# CITY OF ALBUQUERQUE

March 23, 2023

**Re: McDonald**  
**1901 Ladera Dr. NW**  
**Traffic Circulation Layout**  
Engineer's Stamp 02-16-23 (H09-D020)

1. MARKINGS FOR STREET SHALL BE ACCORDING TO REQUIREMENTS AS OUTLINED IN CHAPTER 3B OF THE MANUAL OF UNIFORM TRAFFIC CONTROL DEVICES FOR STREETS AND HIGHWAYS.

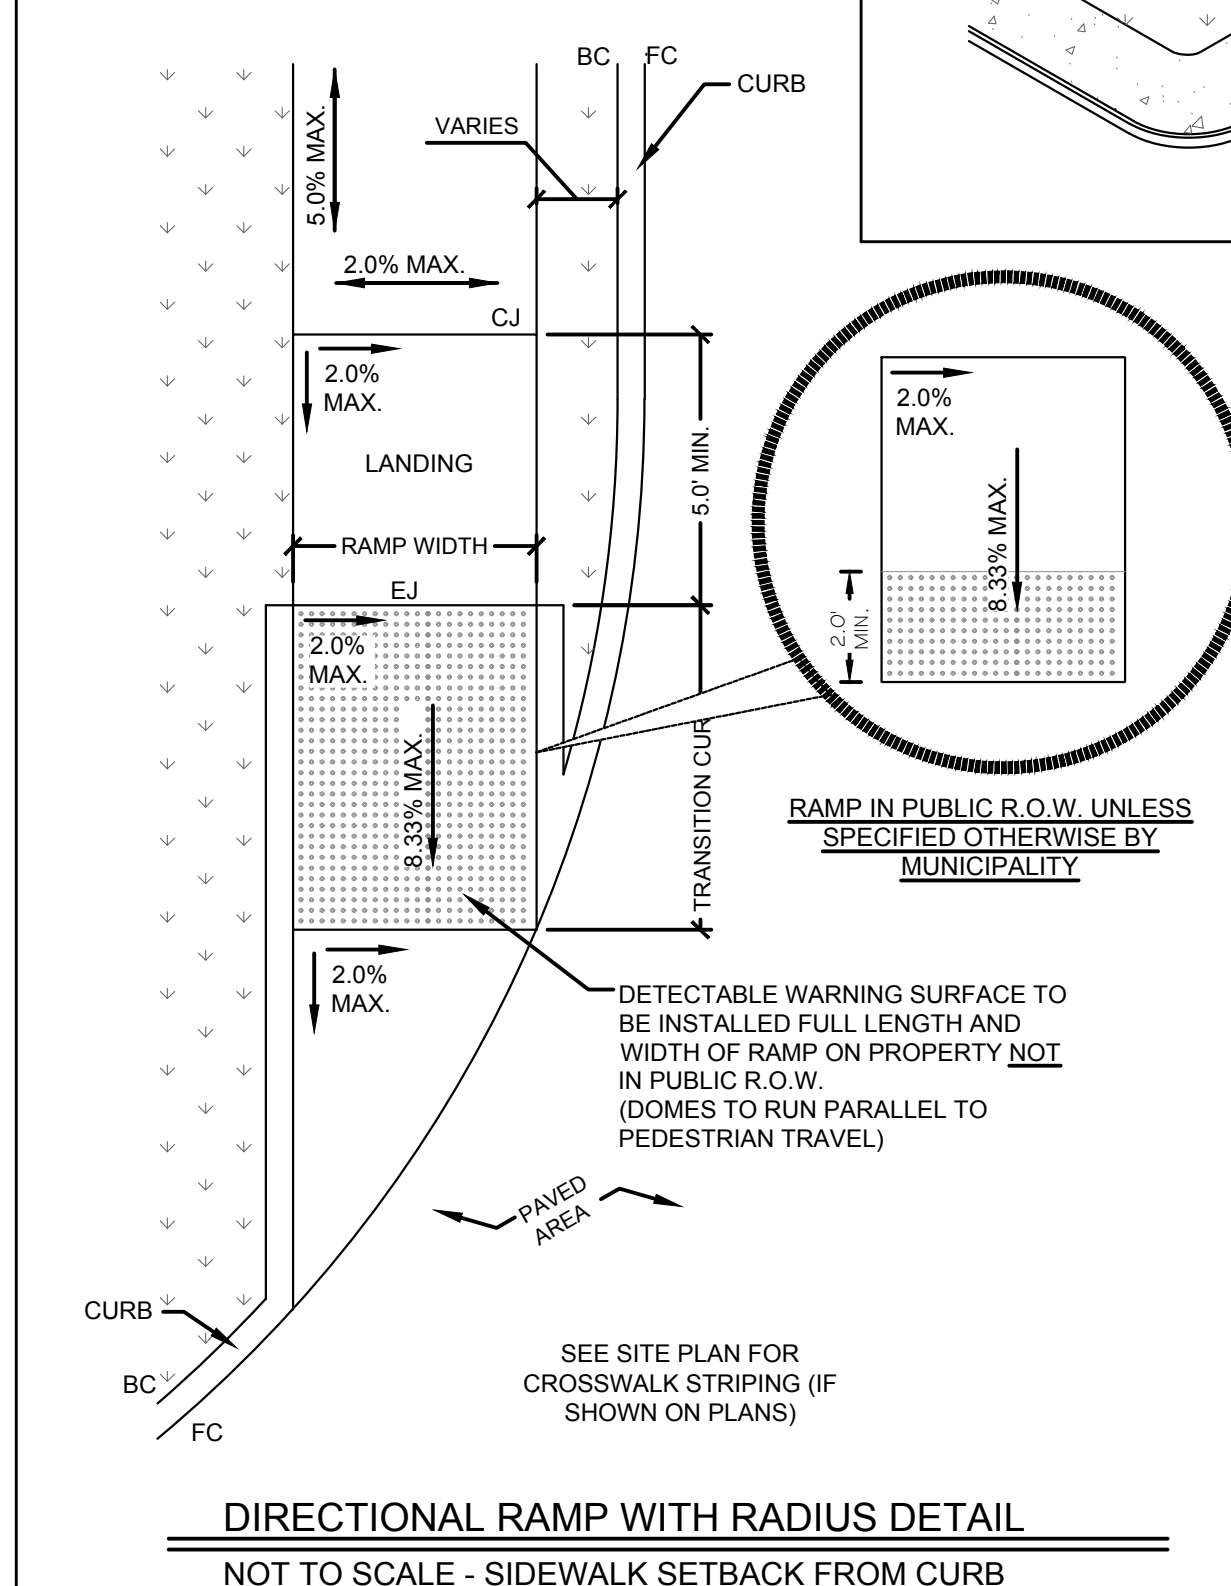
1. List the number of Bicycle parking spaces required by the IDO. Please show it on the site plan on the parking calculation table. Please provide Bike Racks details.

2. Please revised the dimensions for the proposed angled parking at the north side of the site. See attached dimensions or angle parking.
3. Please provide the dimensions for the Intersection clear sight triangle and add the following note to the plan: "Landscaping and signage will not interfere with clear sight requirements. Therefore, signs, walls, trees, and shrubbery between 3 and 8 feet tall (as measured from the gutter pan) will not be acceptable in the clear sight triangle.

4. Key note 30: in addition to the stop sign, please provide "STOP" & "DO NOT ENTER" pavement marking.
5. Please provide coy of Fire Marshal and Solid Waste approval.

6. It is not apparent what type of pavement surface is being proposed. A hard driving surface will be required as part of this proposed project for parking area and drive aisles.

7. Please specify the City Standard Drawing Number when applicable.
8. Add a note stating "All broken or cracked sidewalk must be replaced with sidewalk and curb & gutter." A build note must be provided referring to the appropriate City Standard drawing.
